The Sizewell C Project, Ref. EN010012

**Issue Specific Hearing 12 (15 September 2021)
– (ISH12) Community.**

Issue Specific Hearing 12 (15 September 2021) - (ISH12) Community.

Post Hearing Submissions including written summary of Suffolk County Council's Oral Case

DRAWING TITLE:
 SUFFOLK COAST PATH AND FUTURE ENGLAND COAST PATH DIVERSIONS - CONSTRUCTION PHASE

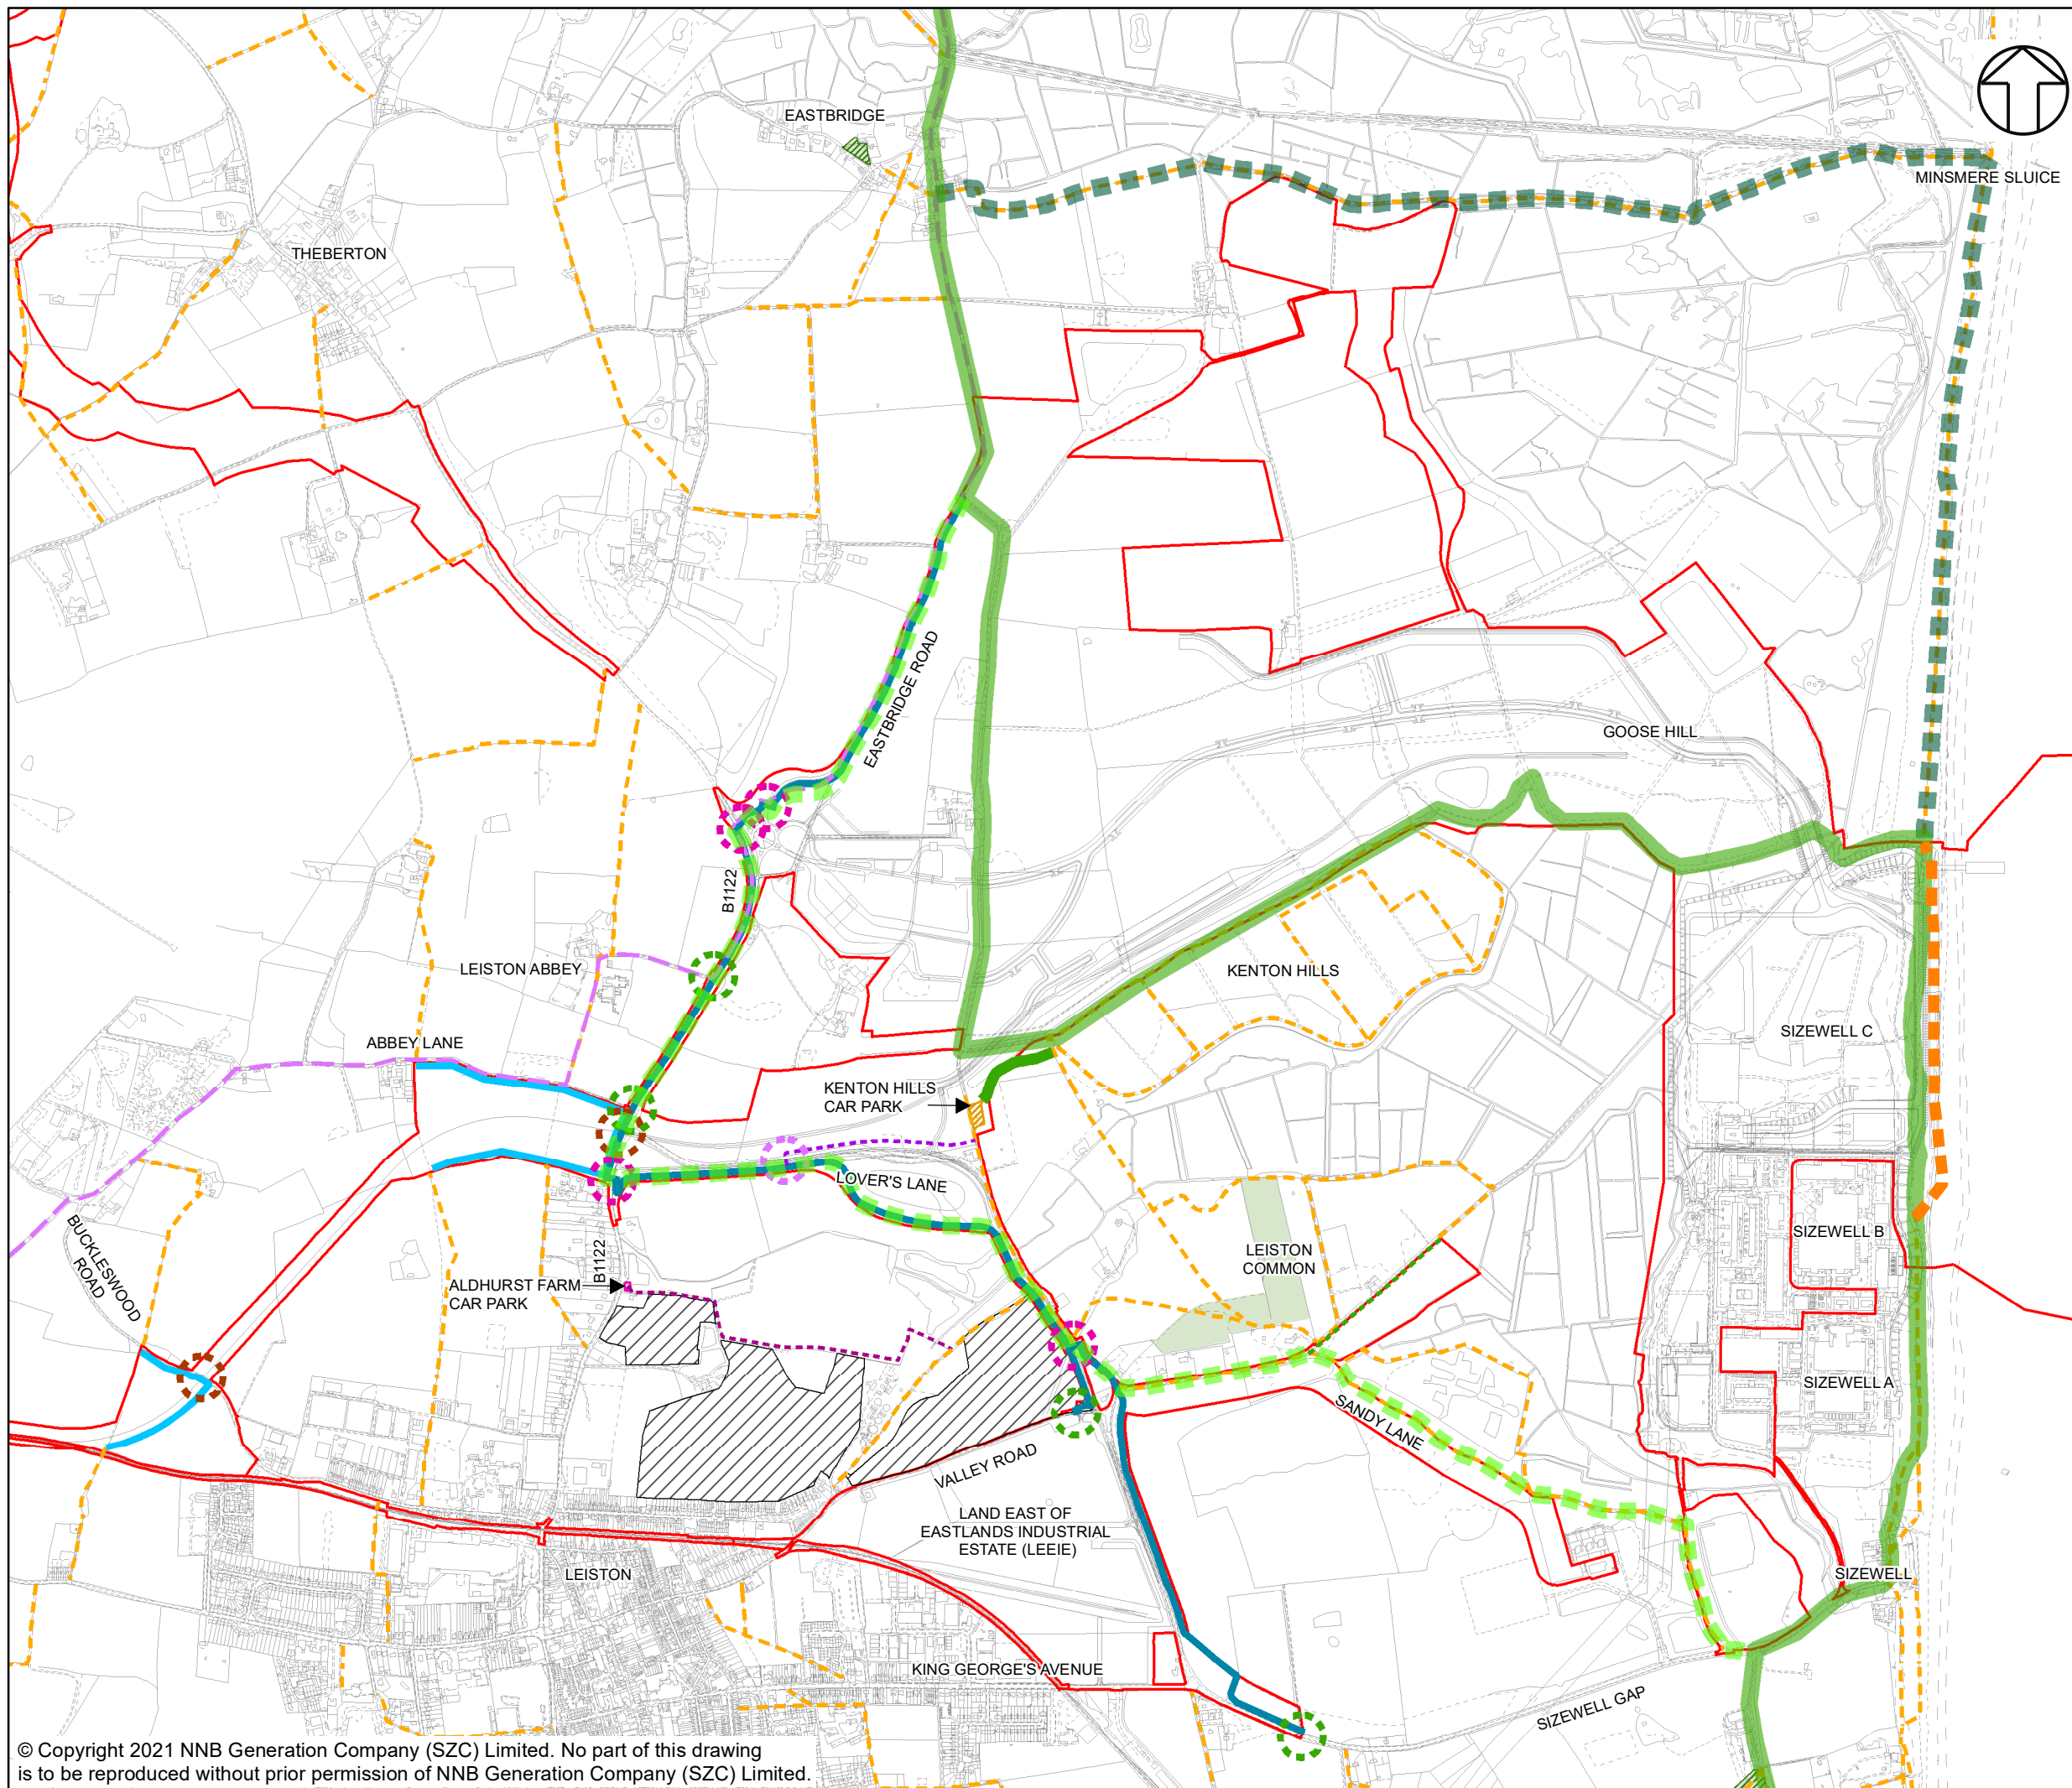
<p>i) Suffolk Coastal Path</p>	<p>Suffolk Coast Path. This is also FP21, which is a public highway (PRow). As the highway authority, SCC wants to ensure as far as possible its asset is protected against future threats and changes, and that where a developer or other</p>

<p>agency wishes to change the route or nature of a highway, it is future proofed against threats which might compromise the highway and involve SCC in unnecessary expense.</p> <p>In the case of the coast path, SCC's main interest is in FP21, and to achieve the optimal route for it, acknowledging a major development the scale of SZC will inevitably mean change. The optimal route is considered to be on top of the coastal defence, on a properly constructed and maintained surface of suitable width. This will also give the best views and coastal experience by reason of its elevated position, and SCC considers the proposed route for FP21, on the seaward side of the defence, could serve as a suitable alternative permissive route for those seeking refuge/respice from the SZC construction works, or wanting a less exposed route.</p> <p>Whilst SCC understands from the Applicant's submission at ISH12 that the Applicant considers the threat for the route as currently proposed is not great, SCC notes that the technical work relied on to support that position [REP5-059] includes various caveats regarding the uncertainties of longer term coastal processes (e.g. at sections 7.5 and 7.7), and recognises that "a finite risk will remain that the HCDF could be temporarily exposed (in the case that an extreme storm or storm sequence occurs in the interval between the trigger being activated and conduction of mitigation being possible" (section 7.7), and in any event SCC has not seen a cogent explanation from SZC Co why FP21 cannot be on top of the defence.</p>
